Application for Planning Permission for Works or Extension to a Dwelling

Development: Single storey part front, part side garage extension.
Part conversion of existing garage and formation of new flat roof over new extension and existing garage including the installation of 2no. roof lights in existing flat roof and render to walls

Location: 23 Mill Lane Rustington BN16 3ED

SINGLE STOREY FRONT GARAGE EXTENSION	LOCATION/BLOCK
23 MILK LANE RUSTINGTON	DE41
MIDLANDS AIRINGFIELD	
SCALE 1:500 1:1250	MAY 2020

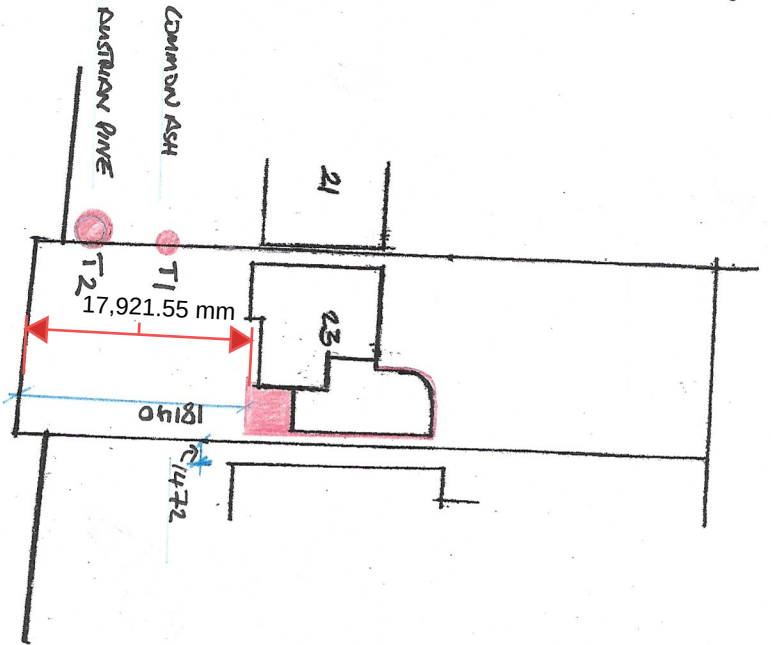
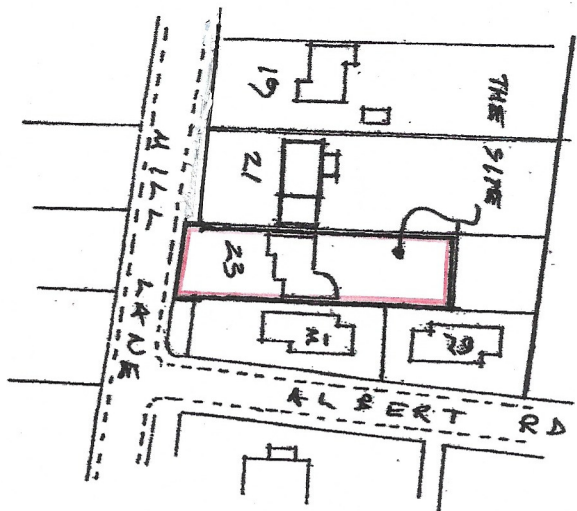
Confirmation Required: Please confirm the full site has been outlined in red on the location plan as the front of the property appears to not have been included within the red outline.

Block Plan: The dimensions on the block plan do not measure to scale. Please amend.

PROPOS 60
23 MILL LANE
BUSTINGTON
SCALE 1:200, 1:100

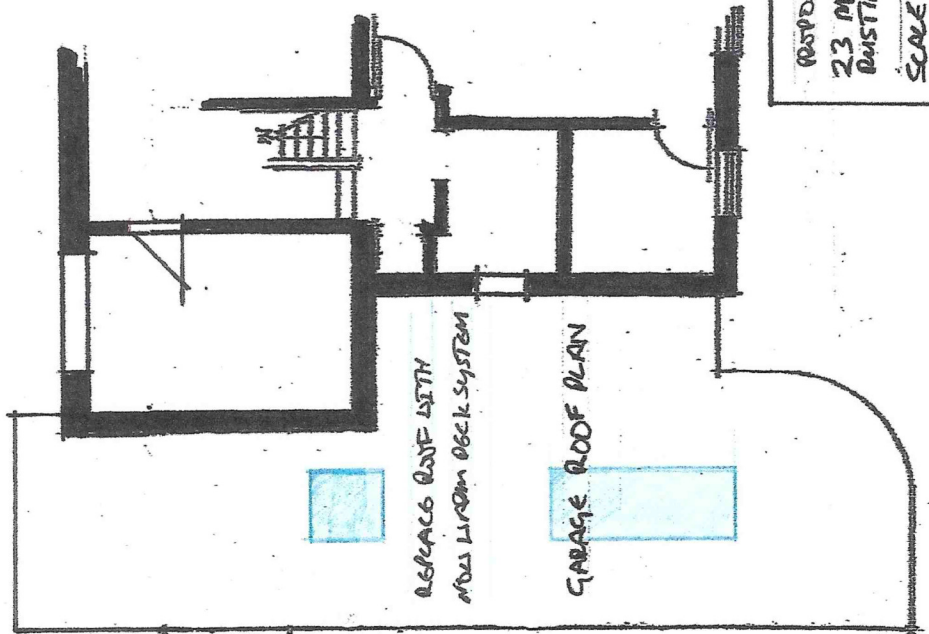
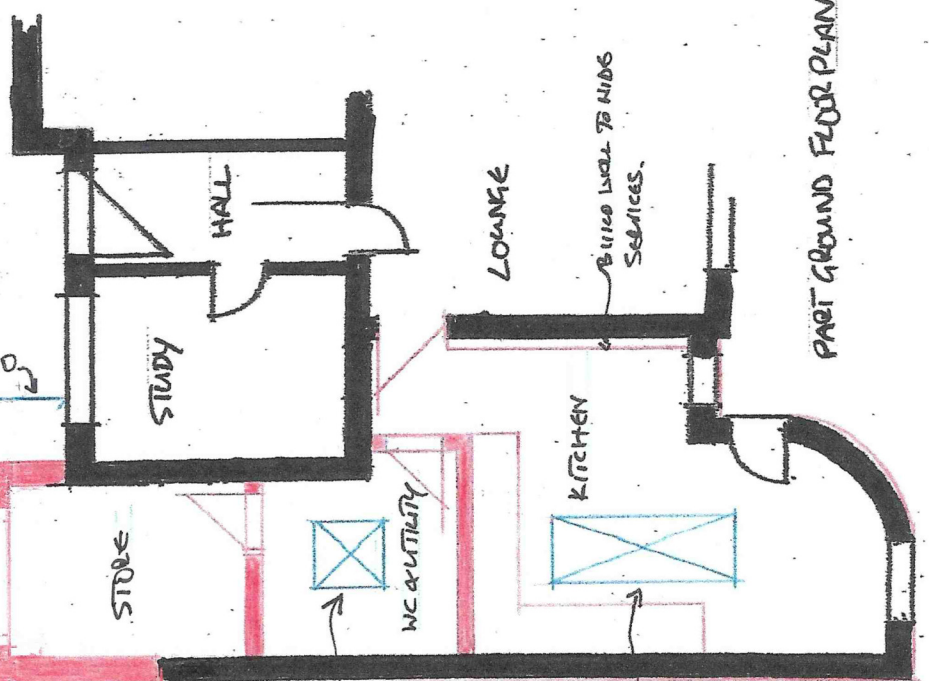
Plans: The plans do not measure to scale due to the incorrect paper size. Please amend.
